SSD-86270706 - 5 Blue Street, North Sydney – Submission

This submission has been prepared on behalf of the Trustees of the Roman Catholic Church for the Archdiocese of Sydney (**CAS**) in relation to the proposed Housing Delivery Authority (**HDA**) State Significant Development (**SSD**) application at 5 Blue Street, North Sydney (SSD-86270706).

The proposed development relates to the adaptive reuse of the existing building known as the Zurich Building.

Figure 1c: Photographs of Wind Tunnel Test Model – Configuration C, awning mitigation scheme

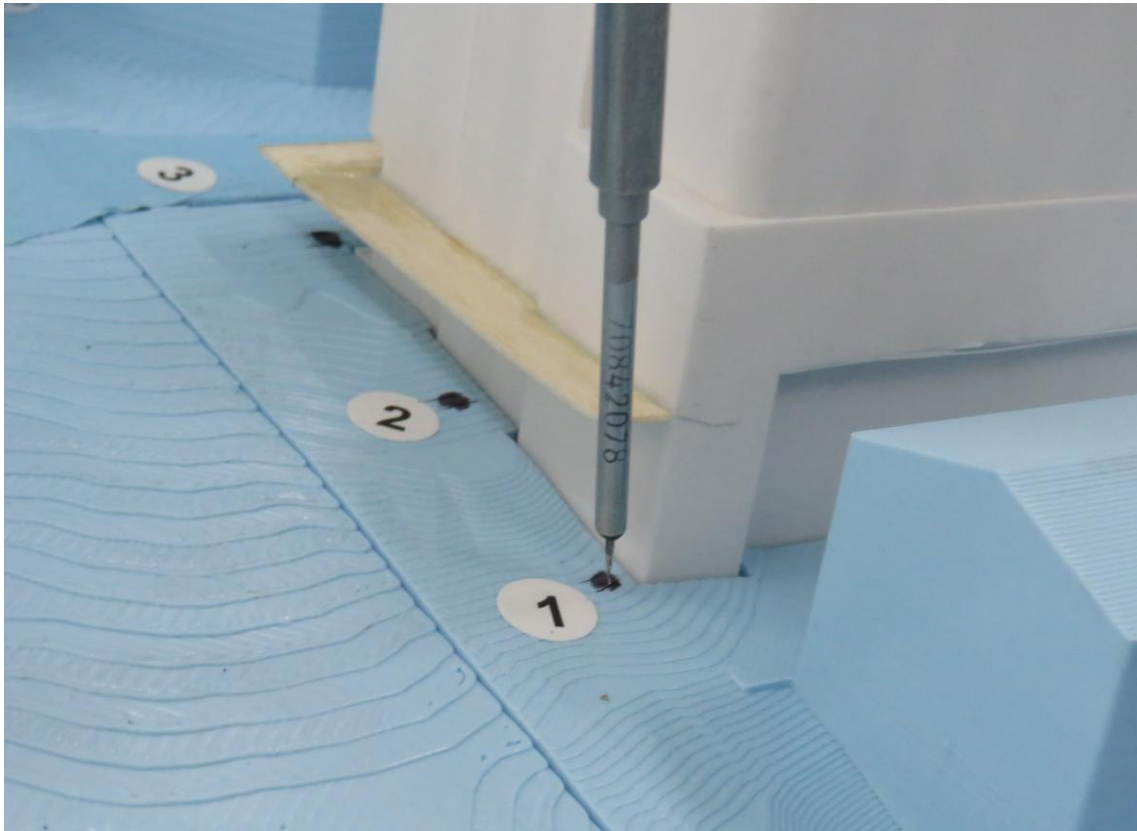
The wind assessment identifies an awning which extends to the north-west corner of the building as a mitigation measure. However, it is not identified if this measure has been included in the design of the proposal, nor is it listed in the mitigation measures table provided as Appendix D to the EIS.

Figure 3: Pedestrian wind speed measurement locations with comfort/safety ratings – North-west isometric view

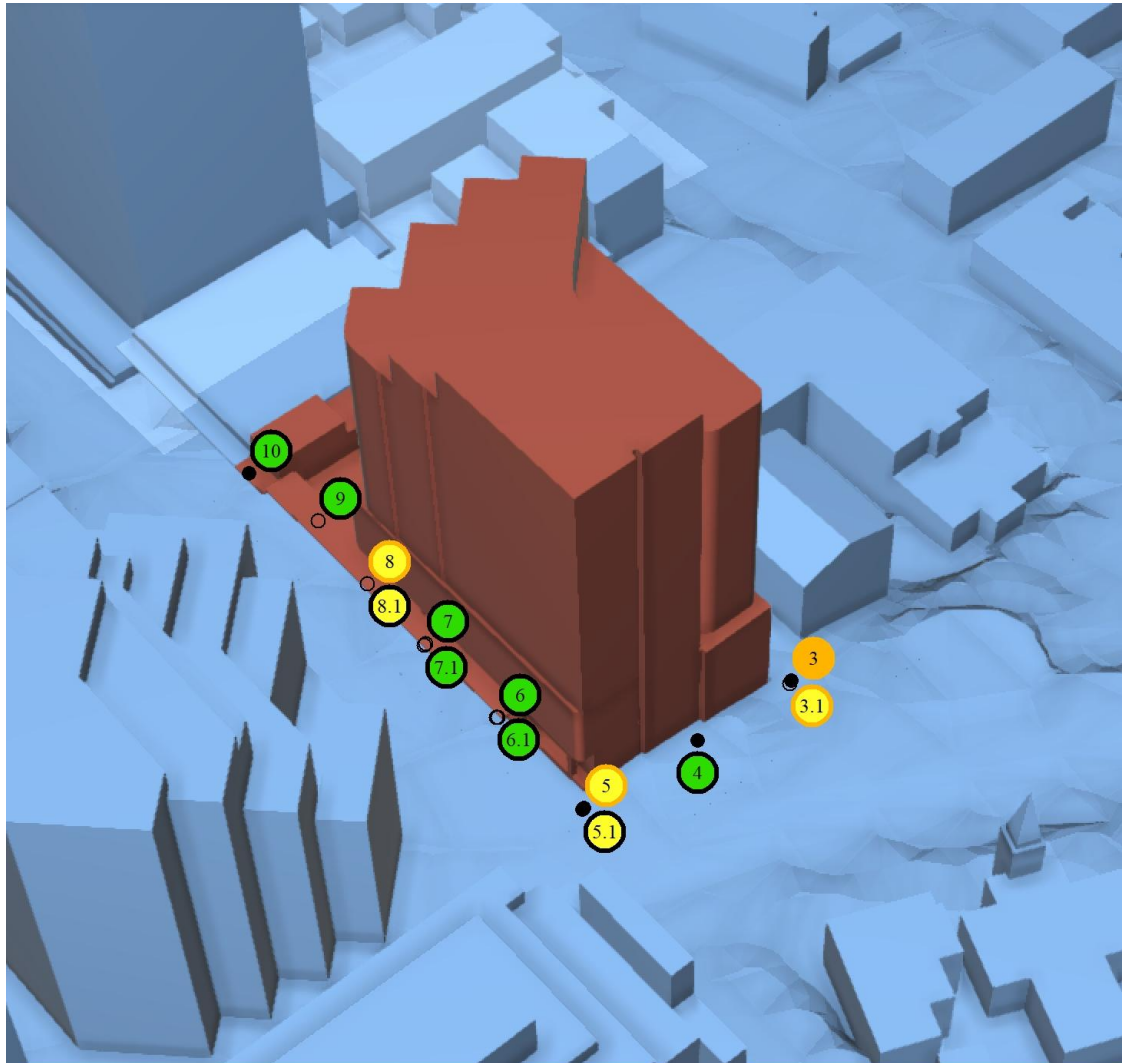
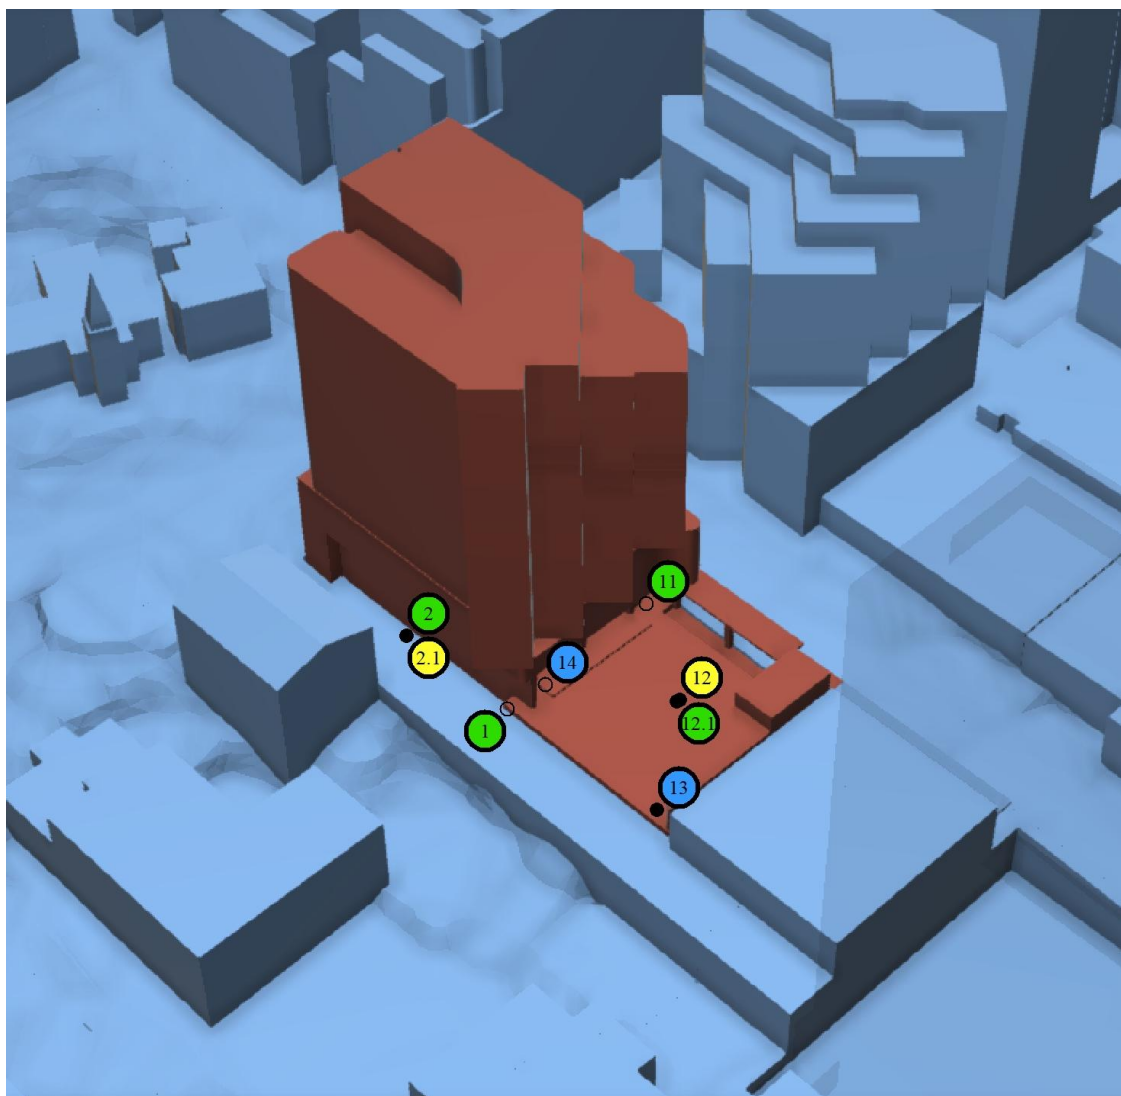
A pedestrian wind assessment was prepared for SSD-86270706 by CPP Wind Engineering Consultants. The wind assessment found that *‘The building corners at Locations 3, 5, 8 are windier with Lawson comfort ratings of Pedestrian Walking to Business Walking and all with safety exceedances of Able-Bodied’ and ‘all locations except 3, 5, and 8 pass the safety/distress criterion.’*

This assessment is incorrect. The proposed development results in an increase in wind impact in three locations.
